# Wansford Parish Council

## Comments on D2 Submission by National Highways

### TR010039-000555-7.6 Arboricultural Impact Assessment

#### A47 Wansford to Sutton Dualling

Appendix 3: TPO & CA Search Results

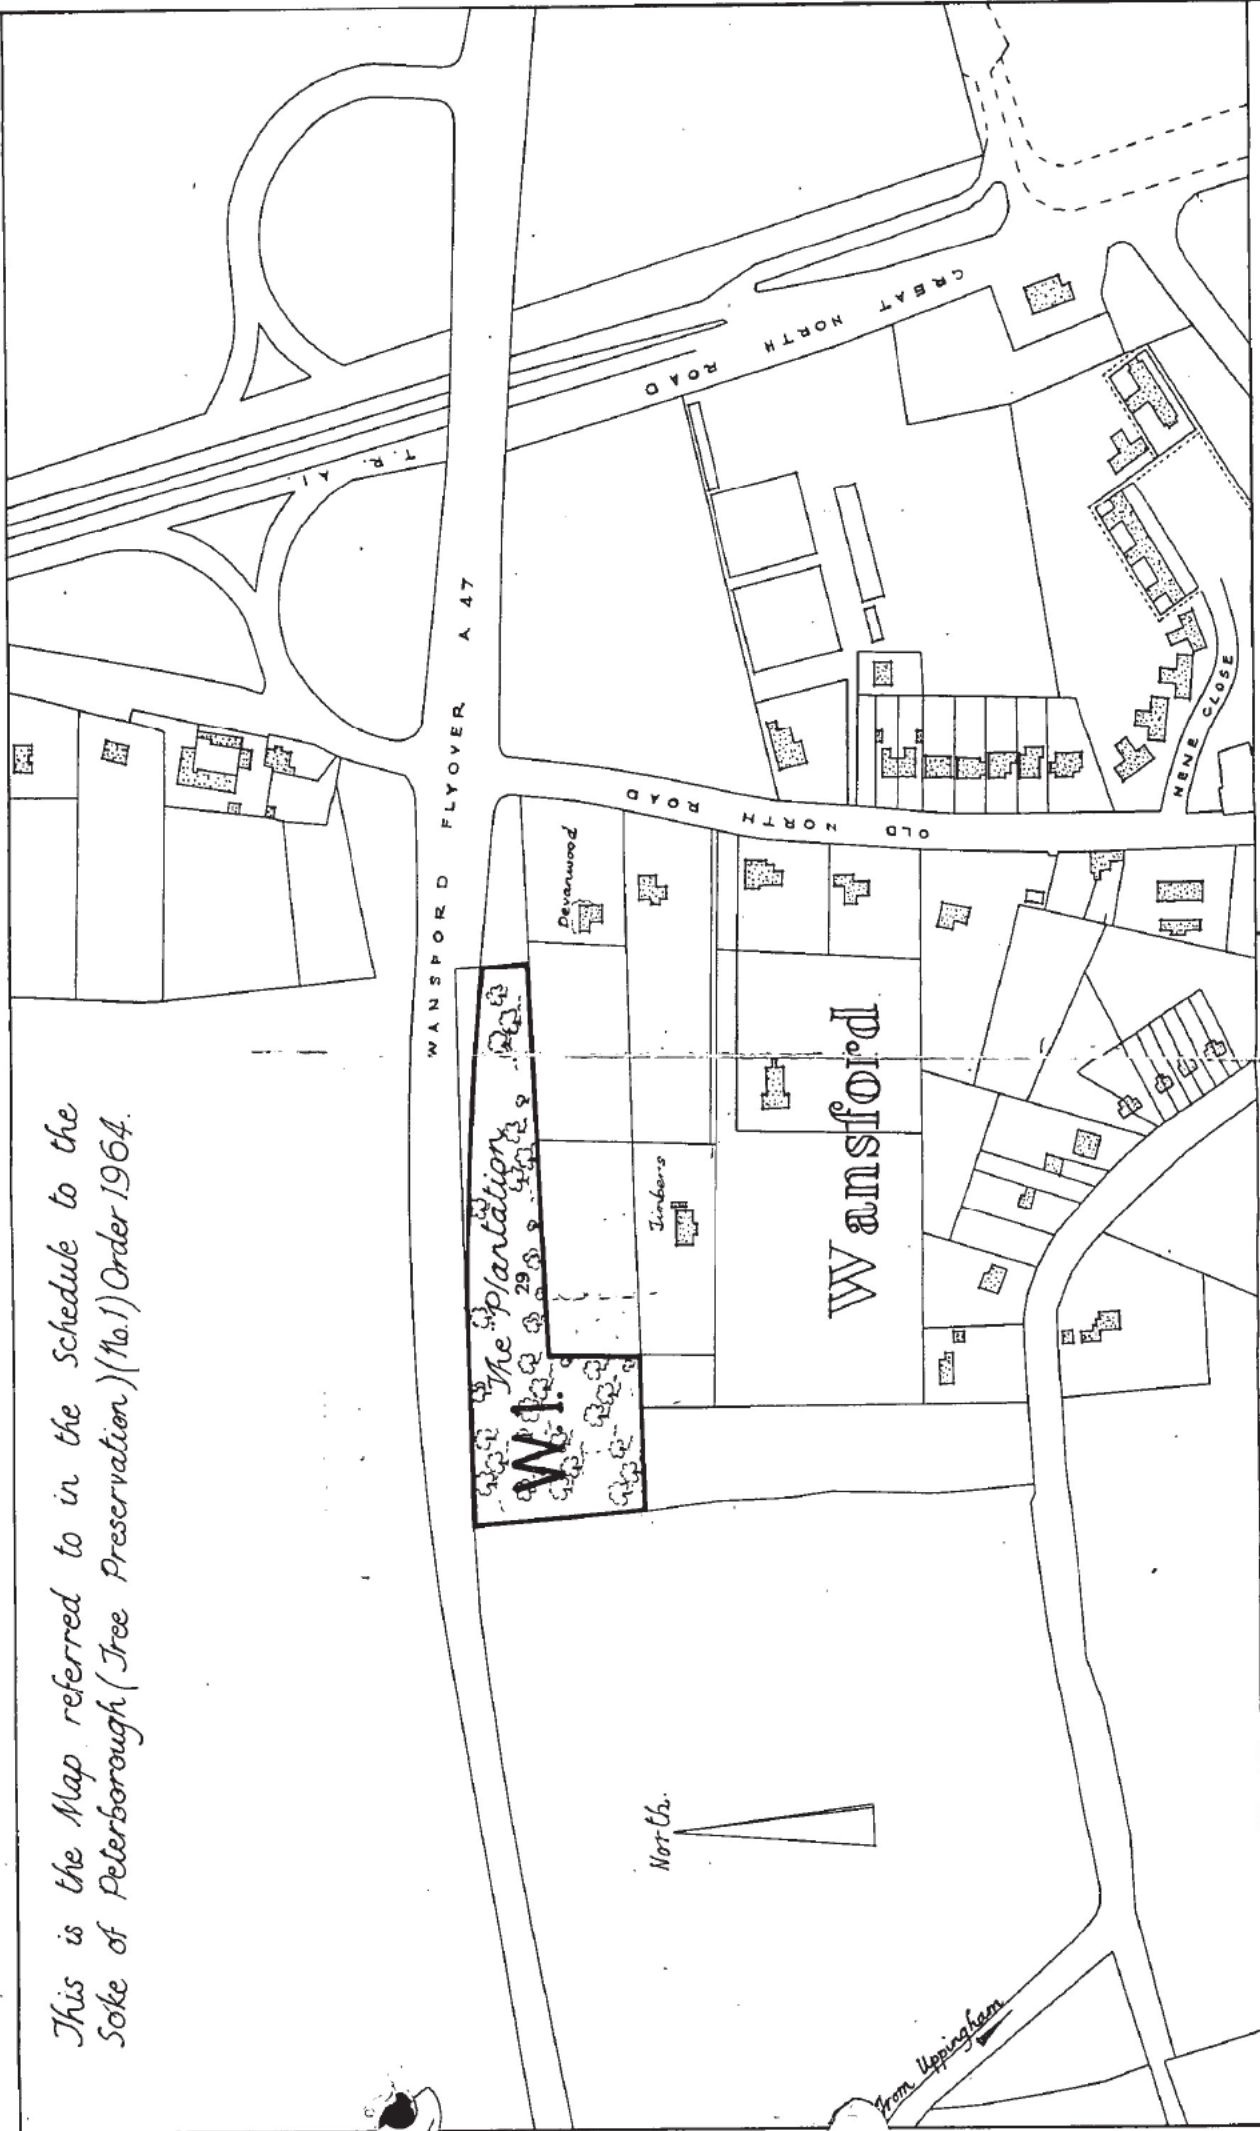
Appendix 3 of the document contains a somewhat random series of documents, several of which are not current. This gives little confidence that all the relevant data has been collected.
